### City of Albuquerque

RE: REVISED DRAINAGE PLAN FOR NEW MEXICO ACTIVITIES ASSOCIATION (L-15/D36) ENGINEER'S STAMP DATED DECEMBER 12, 1990

RE: DRAINAGE PLAN FOR NEW MEXICO ACTIVITIES ASSOCIATION (L-15/D36) RECEIVED 11/20/90; DATED 11/27/90

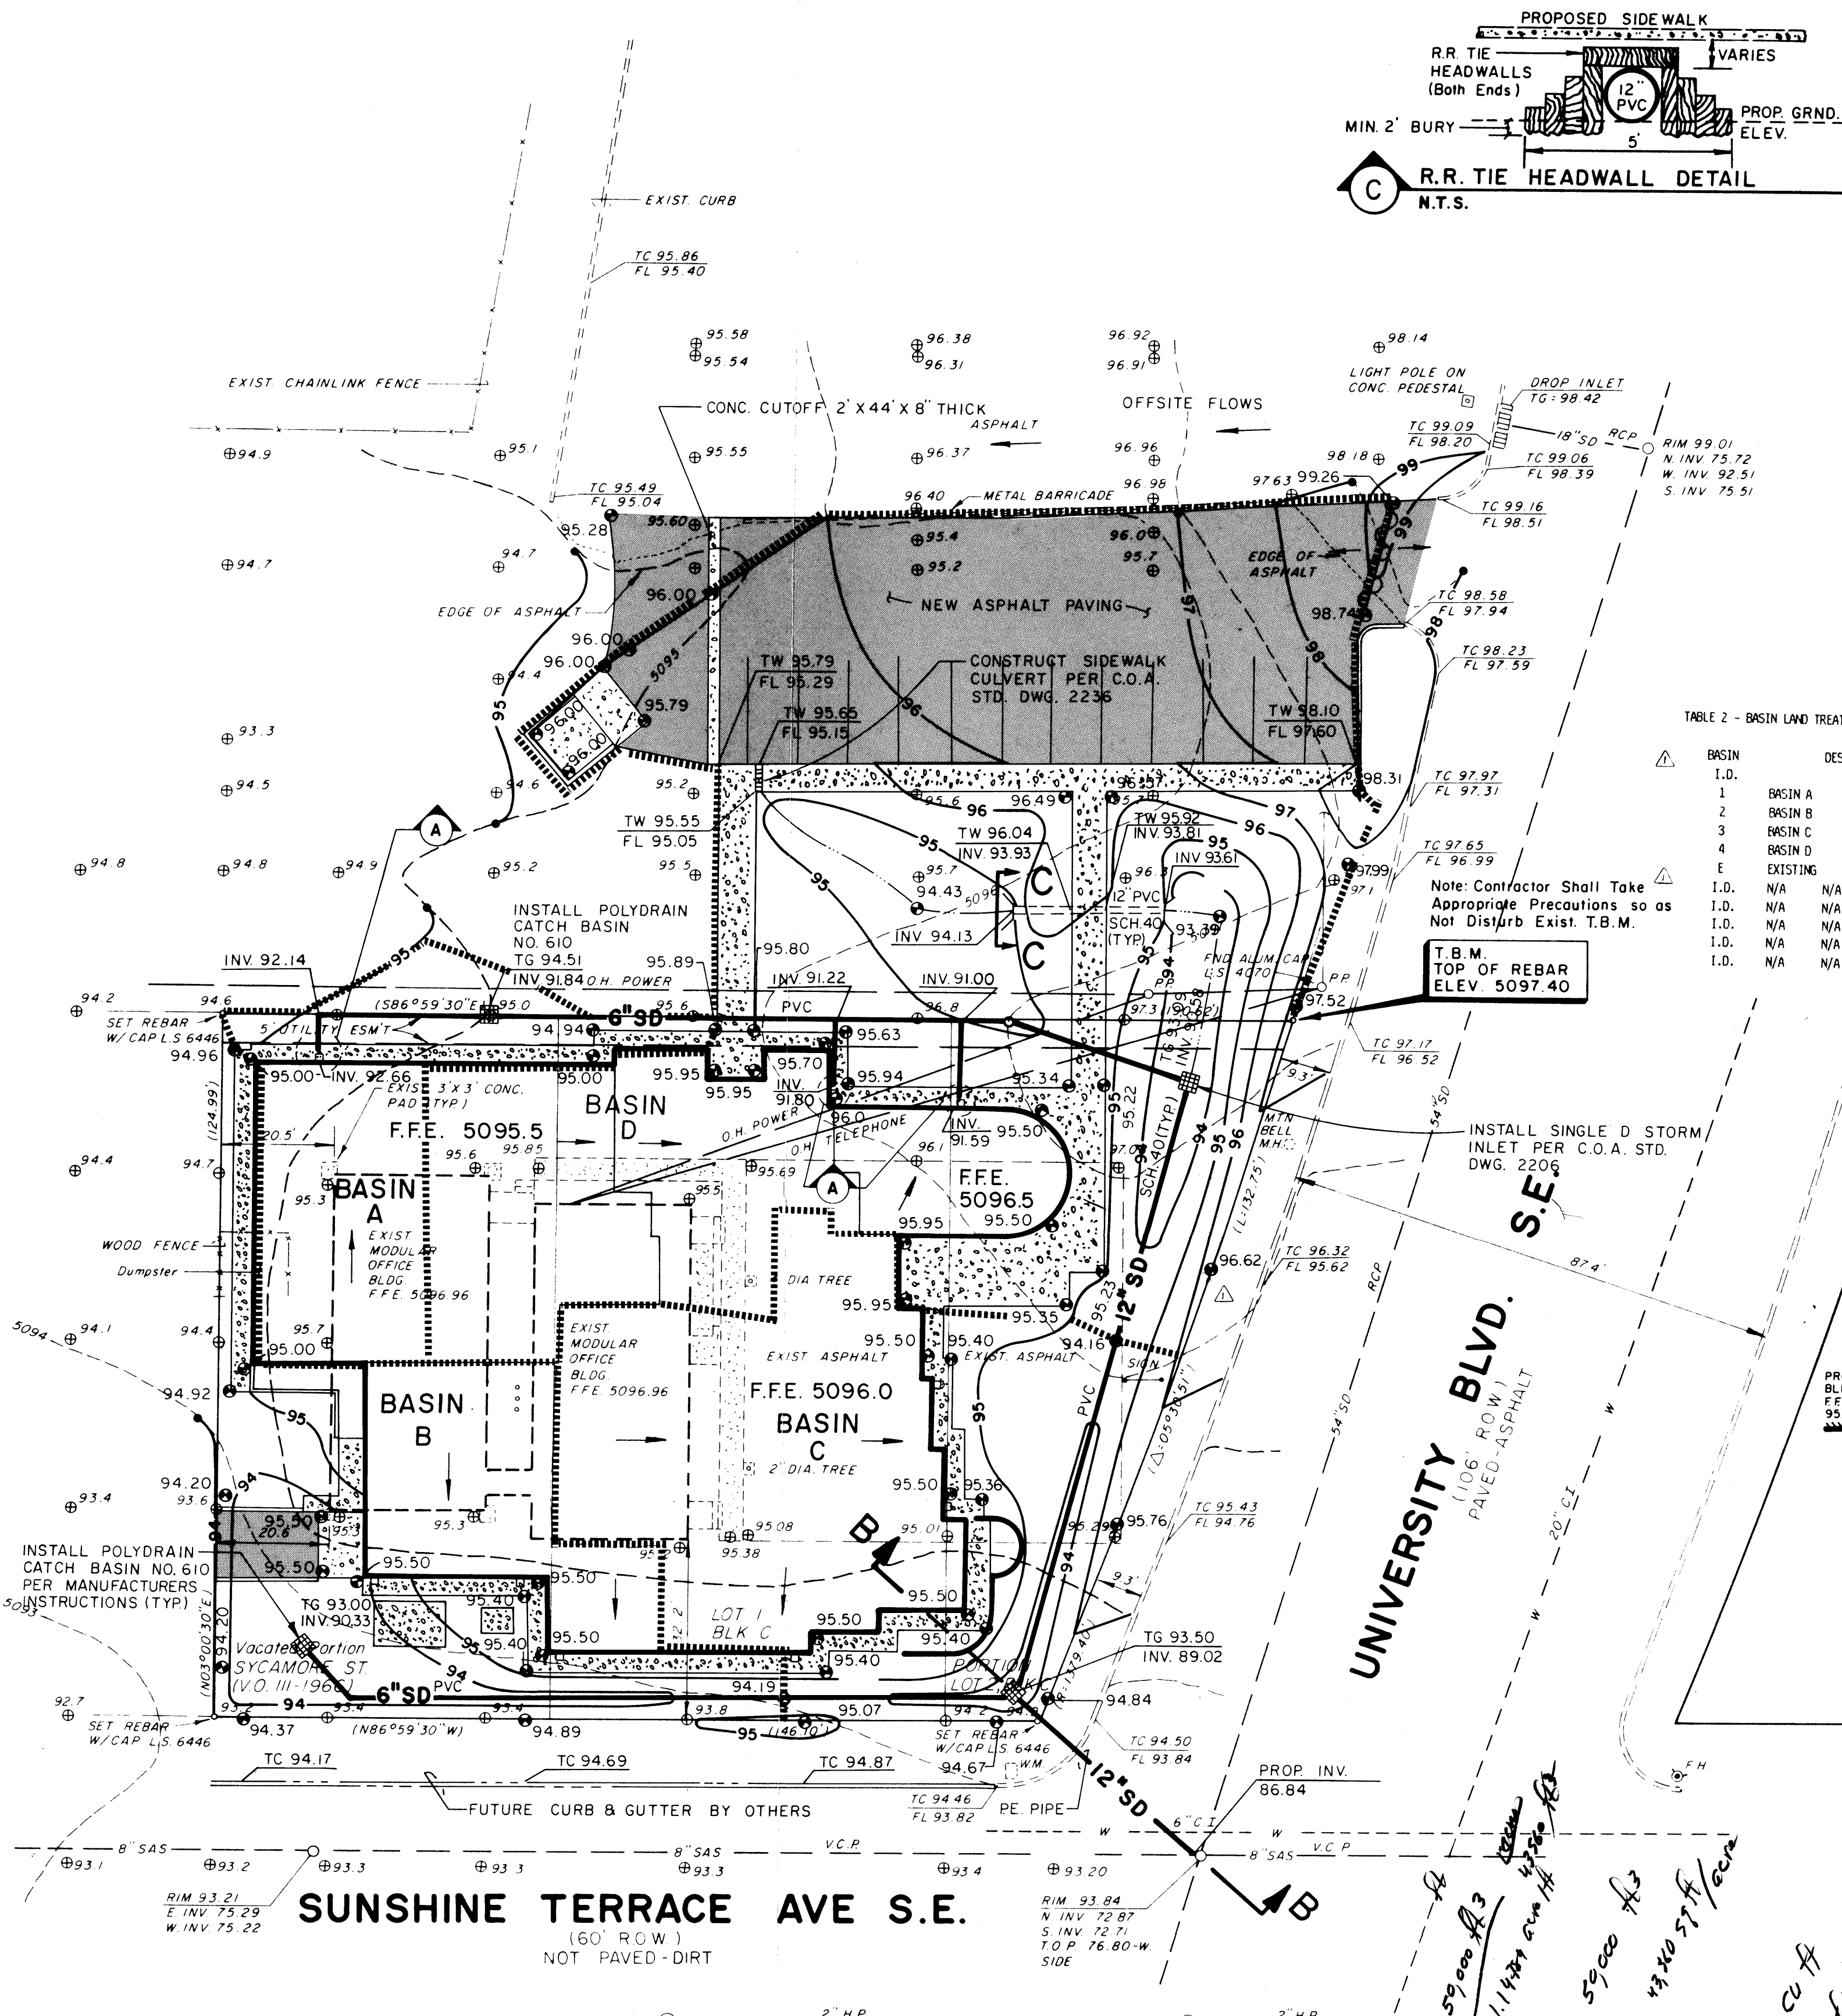
Also, in future submittals please use the Mayor's Emergency rule and D.P.M. to compute your "C" composite and Intensity. The new Hydrology using the Land Treatment Classification has not yet been adopted for D.P.M. use.

- 1. Elevation at property line along University Bouelvard must be one foot above the flow line of the gutter.
- 2. Connection to the existing manhole must be coordinated through DRC under work order.
- 3. Your plan drawing indicates that you will be doing work north of Lot 2, which I am assuming belongs to UNM. We will need concurrence from them that they are allowing the work within their property.
- 4. Please include your calculations showing how you determined your composite "C" value for each basin and what number you used for your intensity.
- 5. T.B.M. must be established where it will not be destroyed with the grading.

1. PLW HAS BEEN REVISED.	TO MEET /'CRITERIA.		
2. NOTED!			
3. WE WILL NOTTY OWNE	RAND UNM OF YOUR REQUEST-		
	MHYDROLOGY-WE ADDED		
	SSIFIC ATTONS FOR YOUR INFORMATION		
AND USE.			
	BE DISTURBED WHERE IT IS. WE		
	BE DISTURBED WHERE IT IS. WE RACTORS TUST IN CASE Monary.		
12/13/90 If enclosures are not as note	SIGNED: CHRON		
PRODUCT 240-2 (FBS) Inc., Groton, Mass. 01471	d, kindly notify us at once.
